From: Martyn White
Sent: 15 October 2018 12:21
To: Planning.Responses
Cc: Zac Denton
Subject: AB/77/18/PL & AB/78/18/L

AB/77/18/PL & AB/78/18/L

EXISTING
INTERNAL ELEVATIONS & DETAILS.

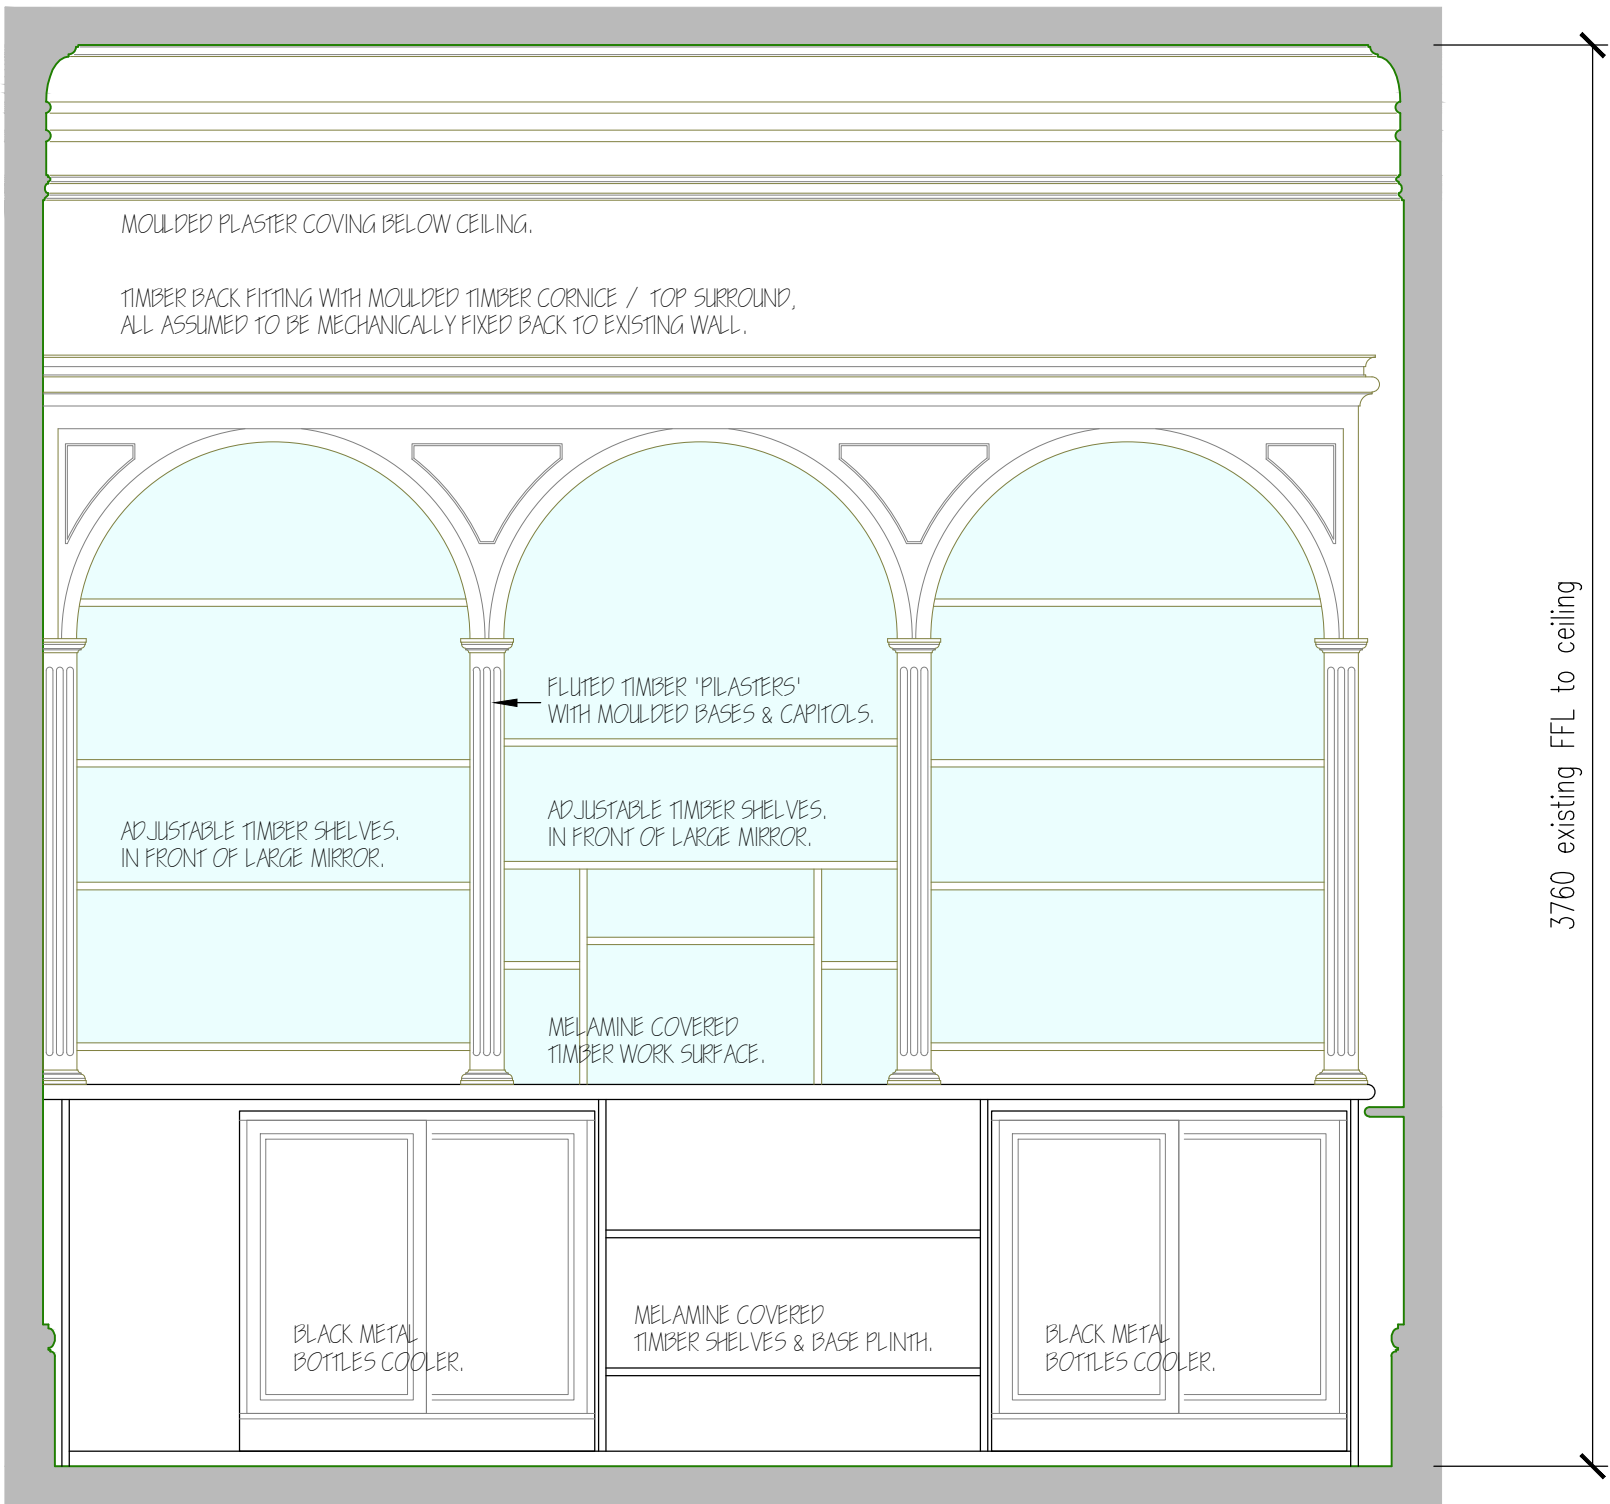
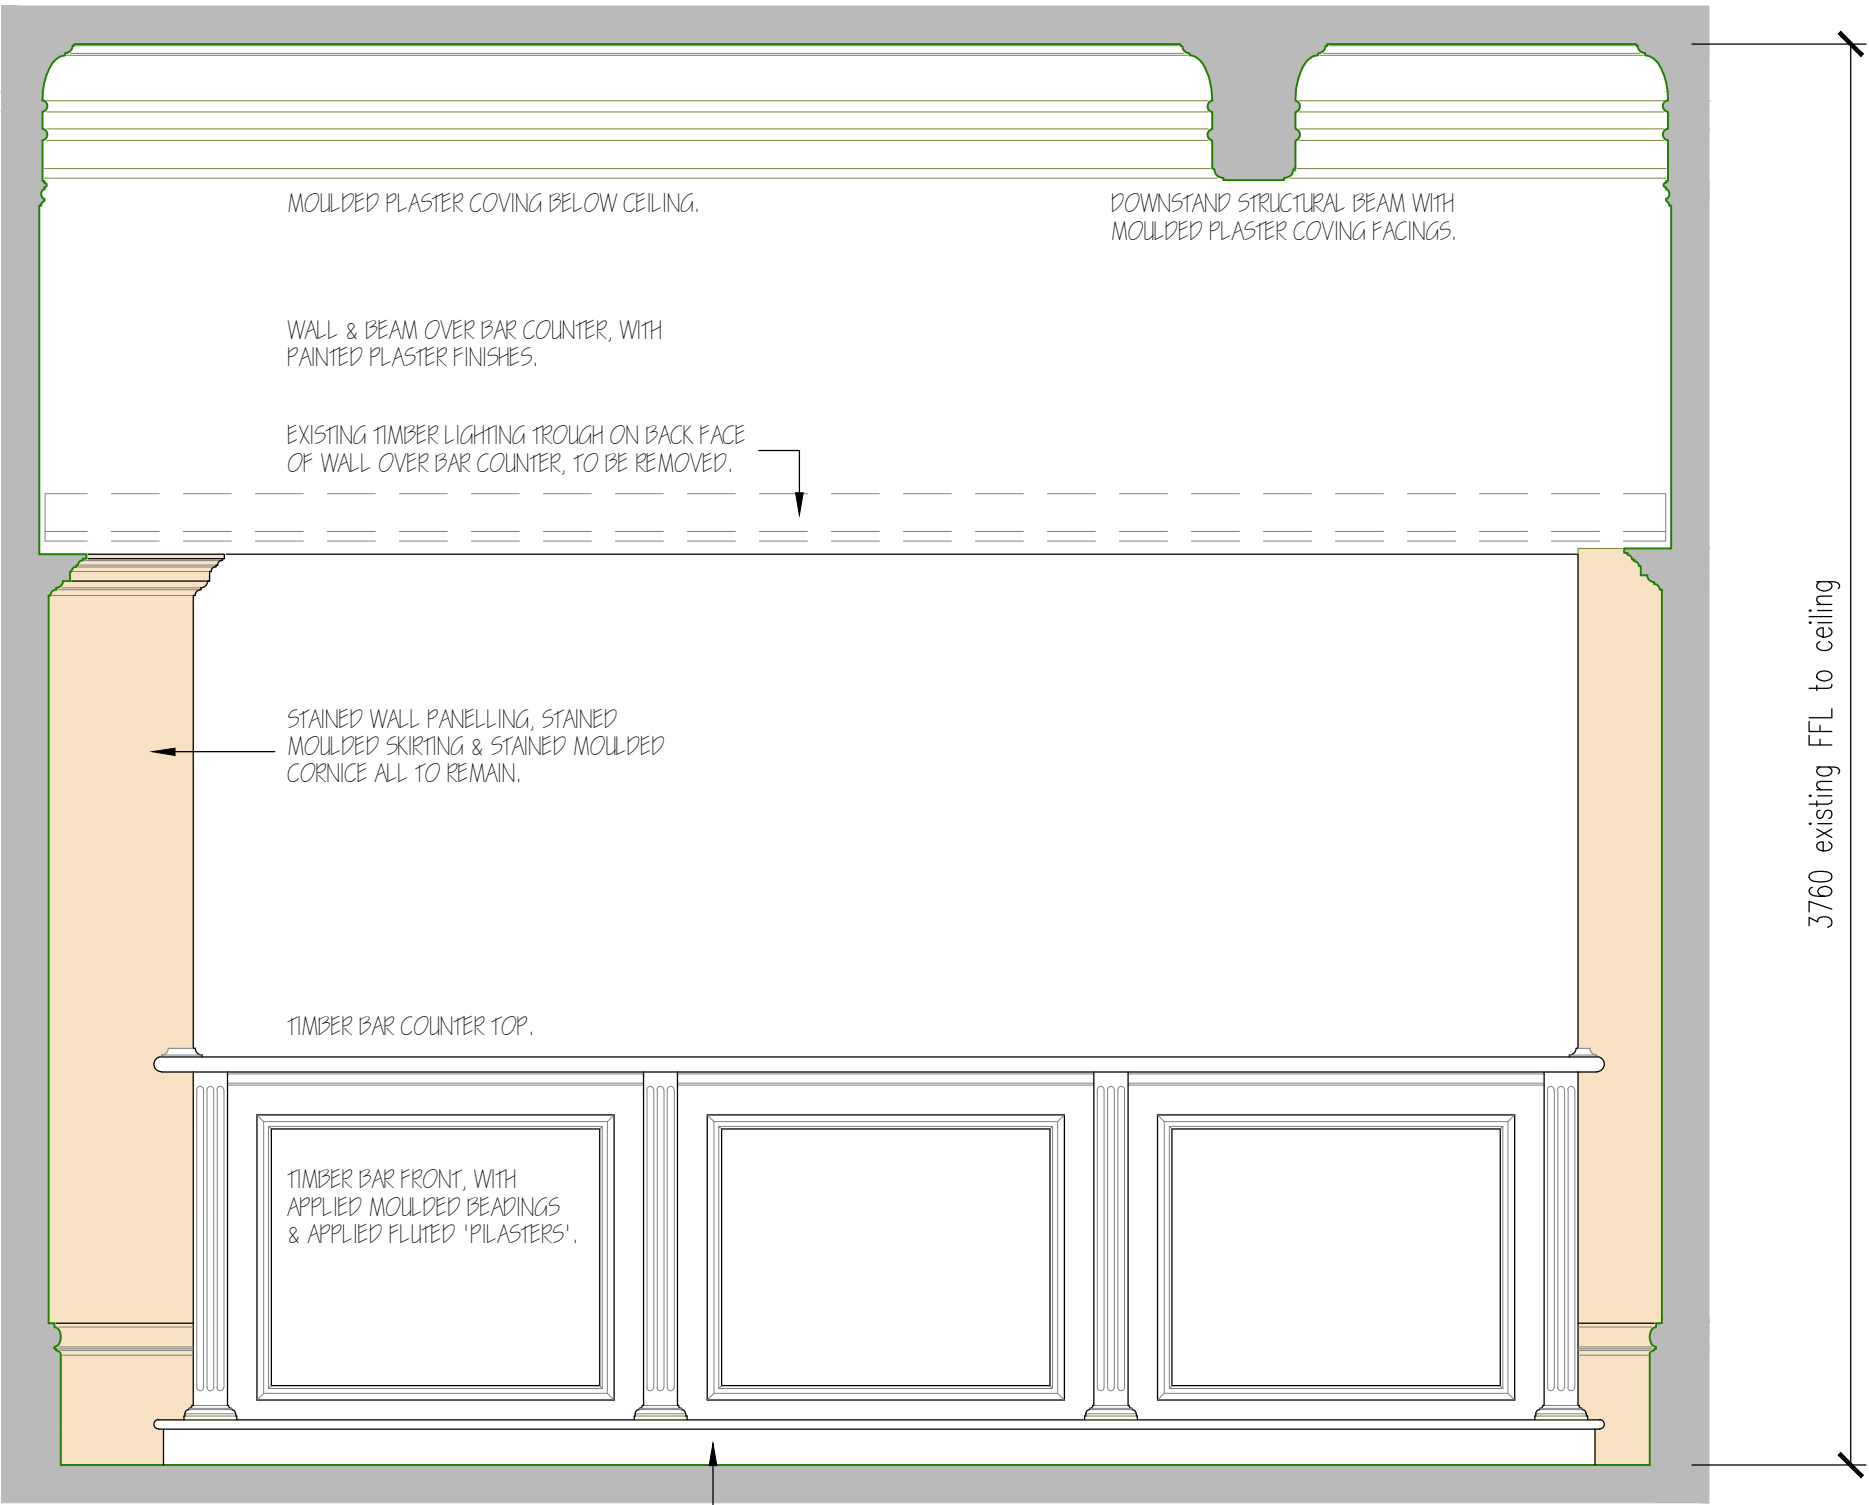
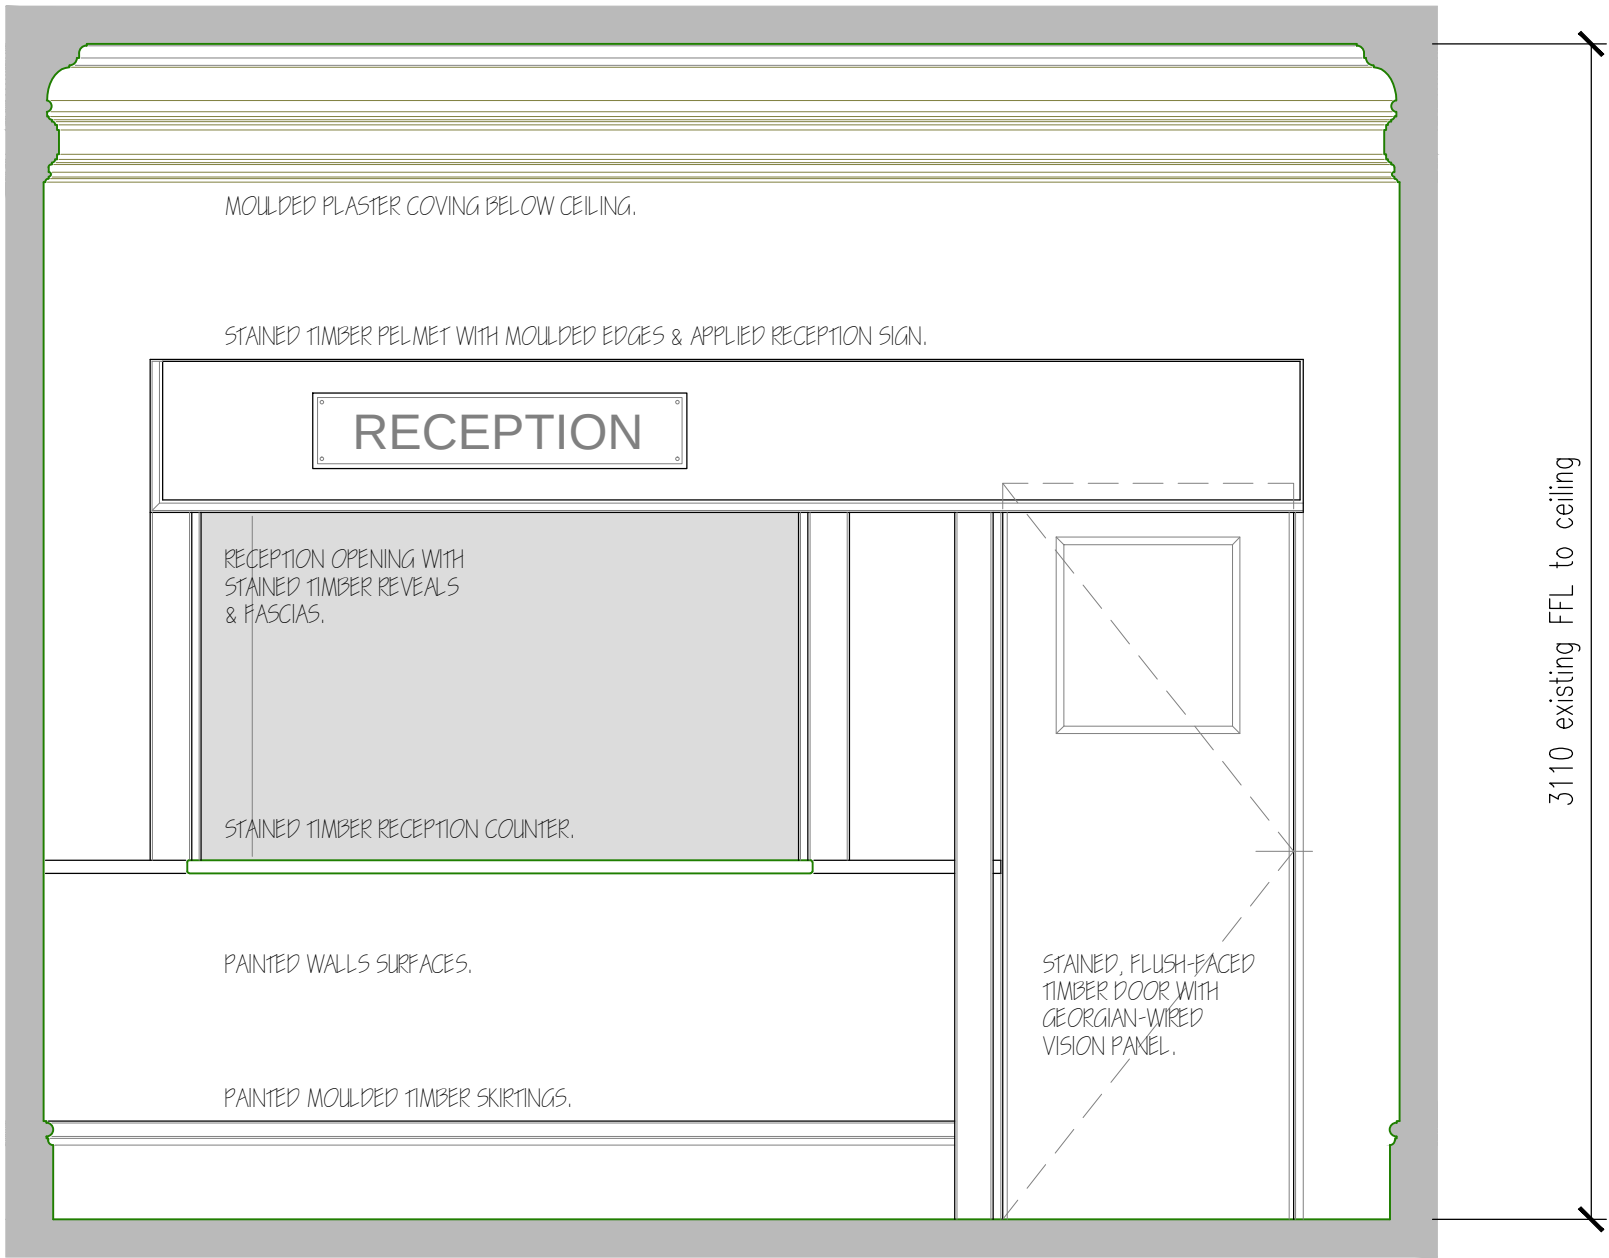
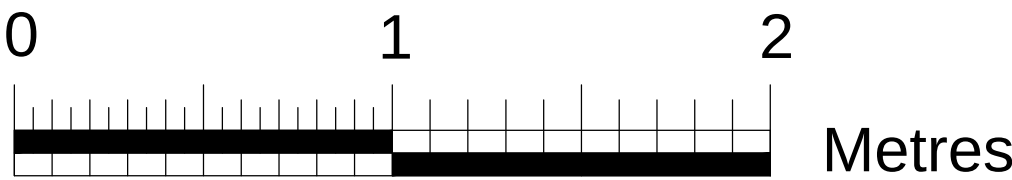
The proposal to re-position the existing reception closer to entrance, in place of the existing 'Norfolk Bar' would seem logical, and not harm the character of the building. Other internal works are mostly small in scale and do not affect the character of the building. In fact, the removal of the 'dumb waiter' will have a positive impact upon the rooms it serves.
